Regulatory, Planning and Assessment. PEmmett/GMansfield
Reference: SDC2021/0003
Phone: 02 4974 2767

21 December 2021

**NEWCASTLE GRAMMAR SCHOOL - PARK CAMPUS (SSD-13895306) –
127 UNION STREET, COOKS HILL**

The exhibited Environmental Impact Statement (EIS) and plans have been reviewed and the following advice is provided for your consideration:

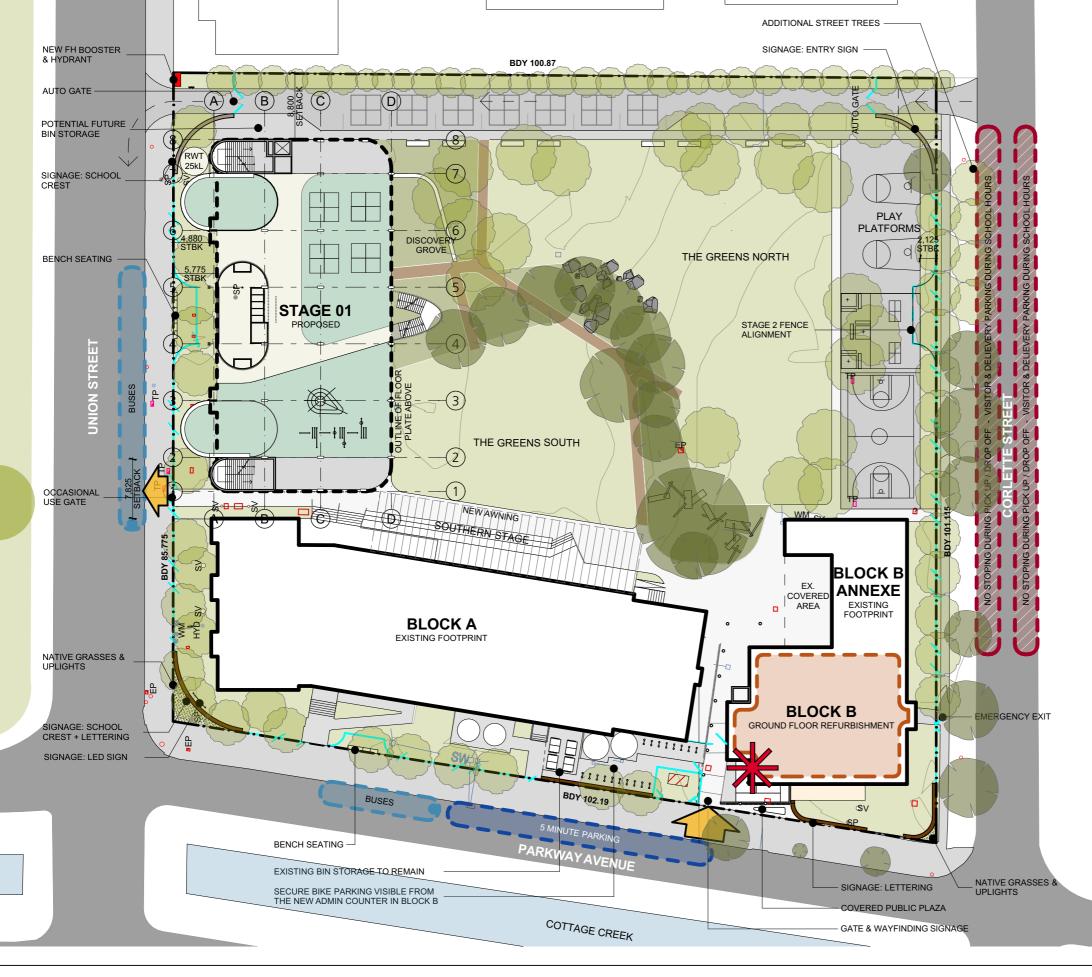
The concept plan does not include the proposed building setbacks of the development. According to the 'Site Plan-Proposed' (4293 2.02 RevN 15.10.21) the proposed Stage 1 building will have a setback of 5.775m to Union St which appears, as depicted on the plan, to align approximately with the setback of the multi-storey residential building on the adjoining property to the north on land known as 308/123 Union Street.

However, according to CN records it would appear that the building footprint is not accurately represented on the above site plan and the minimum building setback (to the balcony) is approximately 7.0m with the western wall set further back. Consequently, the proposed stage 1 building will be located well forward of the adjoining development.

It is recommended the applicant is required to submit amended plans and documentation which accurately indicates the adjoining building forms and setbacks of the existing developments on the adjoining properties, supported by a numerical analysis of the setbacks of the development with those of the adjoining developments.
